PROJECT NO. PR-2018-001579

Application No. SI-2021-00304 SITE PLAN, SI-2021-00305 SITE PLAN AMENDMENT, PS-2021-00040

**January 14, 2022**

**RE: PR-2018-001579 – WINROCK TOWN CENTER, SI-2021-00304 SITE PLAN, SI-2021-00305 SITE PLAN AMENDMENT, SUMMARY PLAT (PLAT OF EASEMENTS ONLY)**

PROPOSED ROAD-E

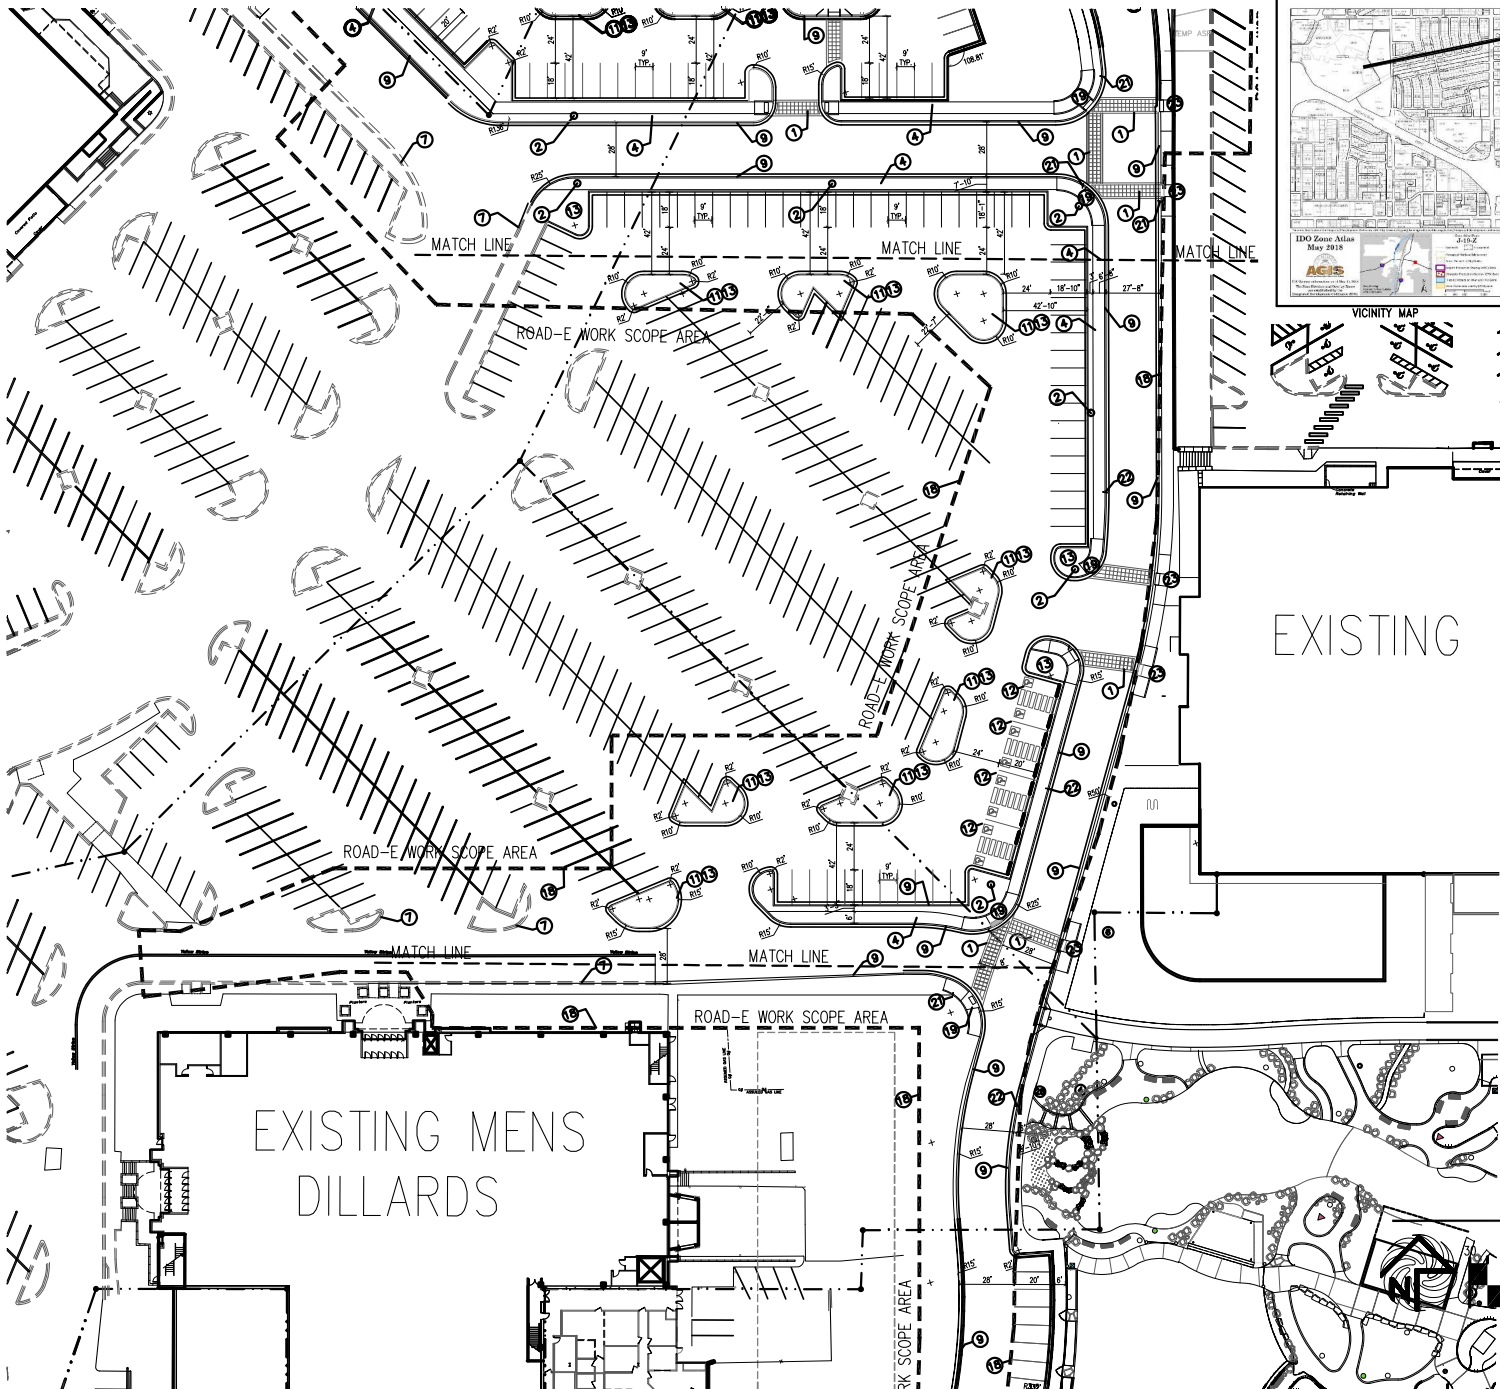
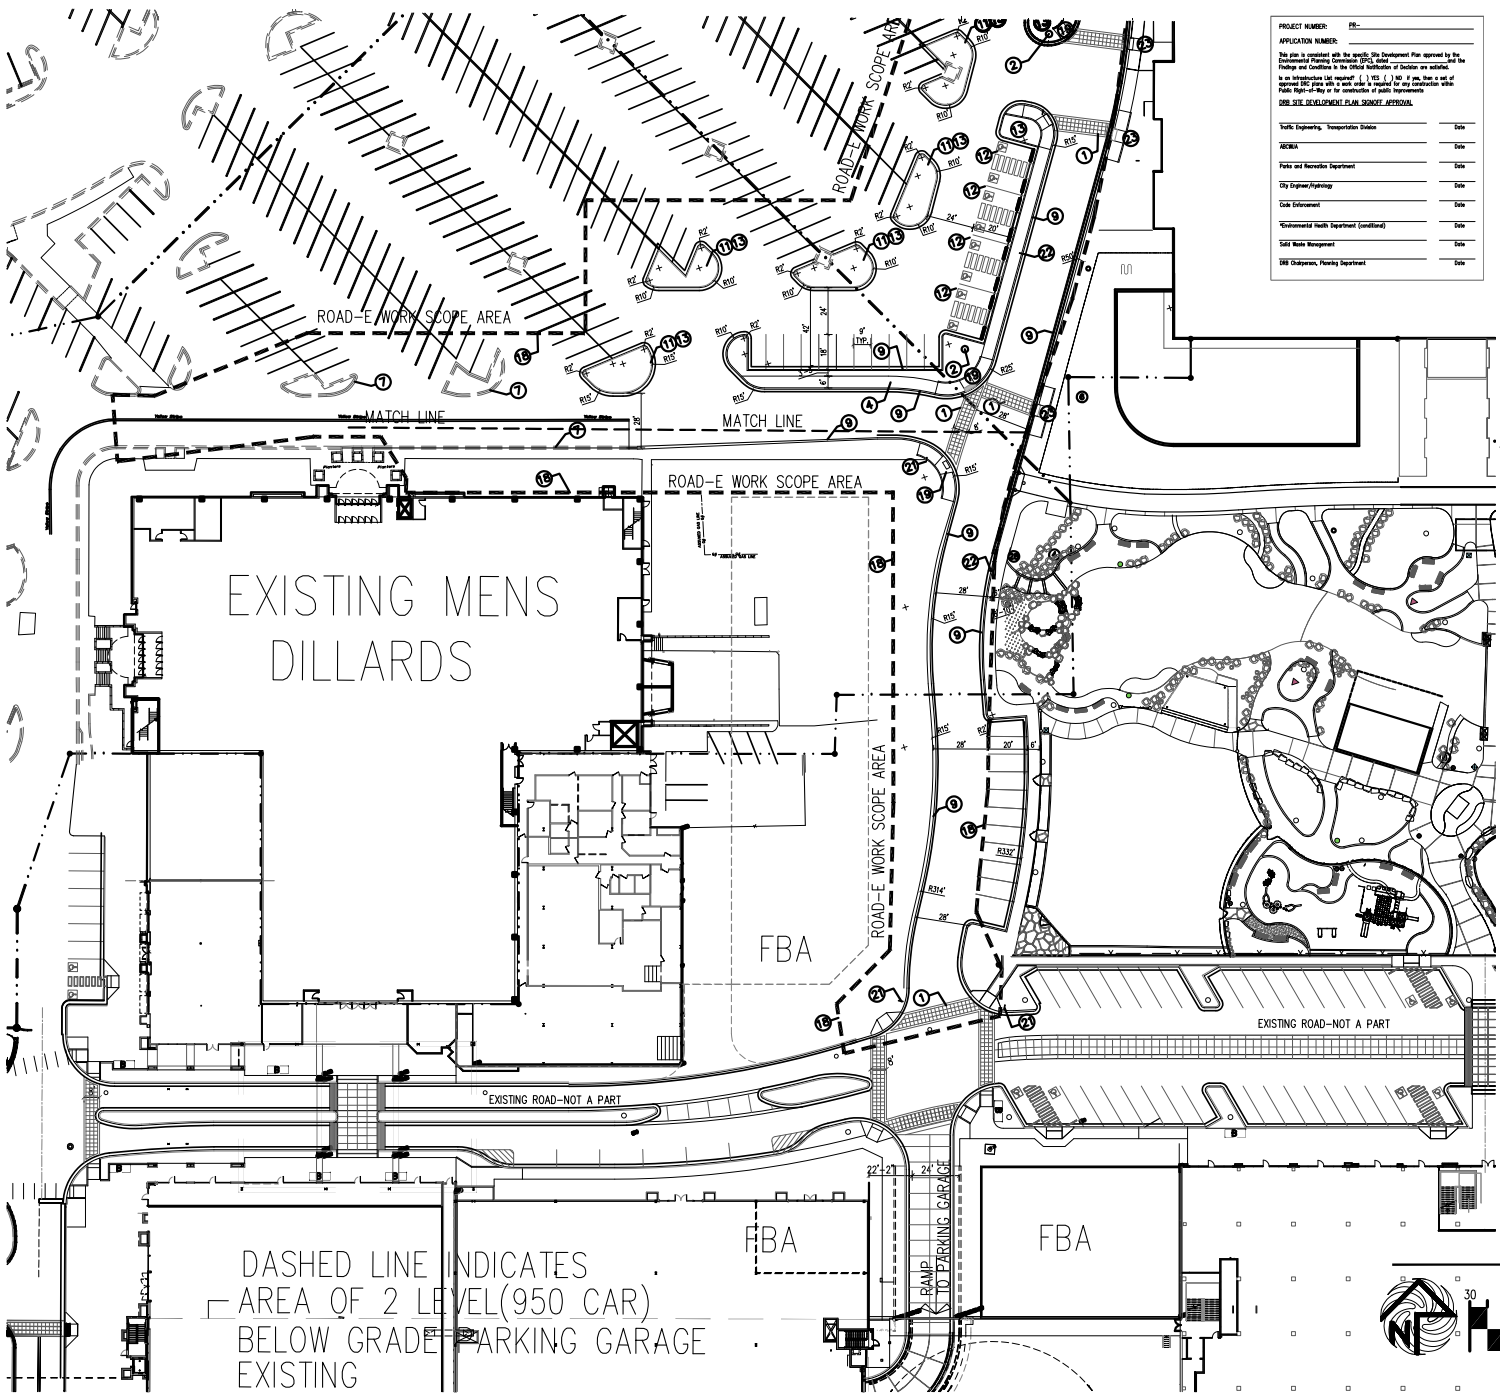
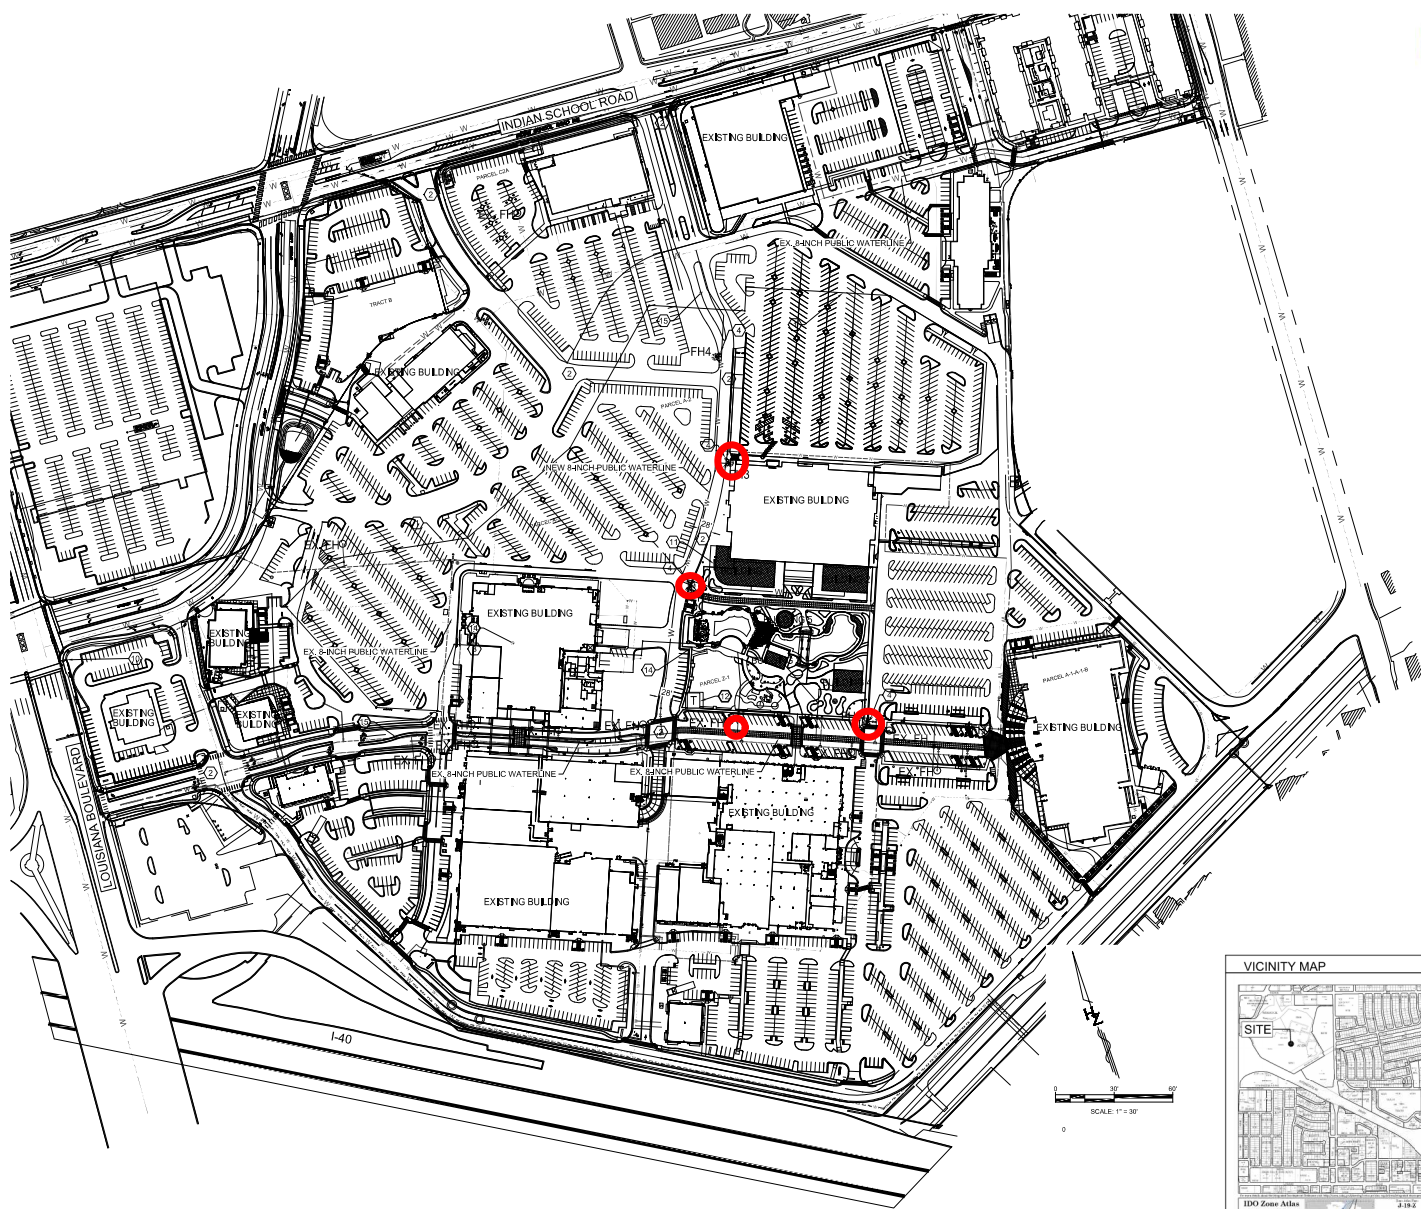
1. Stamp and sign drawings.
  - **Applicant Response: All drawings have been stamped and signed.**
2. Show cross-sections of Roadway E with cross-slopes, lane widths and sidewalks. Call out details for curb.

4. Provide proposed traffic control at each of the new intersections. Add “Yield to Pedestrians” signage for the new crosswalks that are mid-block.
  - **Applicant Response: Proposed traffic control at each of the new intersections are shown on work order plans. Signage has been identified.**

- **Applicant Response: City Project Number 538491 and plans have been submitted to DRC. Shown on work order plans.**
6. Label all new curb ramps on the site plan and reference curb ramp details. (It appears that in some cases, the wrong keyed notes were used for the curb ramps).

- **Applicant Response: City Project Number 538491 and plans have been submitted to DRC. Shown on work order plans per discussion with Jeanne .**
3. Label all handicapped signage and motorcycle parking signage on the plan.

- **Applicant Response: All new and existing curbs have been identified in project area. The details are also shown on work order plans.**
7. “No Parking” shall be called out on all new van accessible aisles. However, this can be handled under the details.
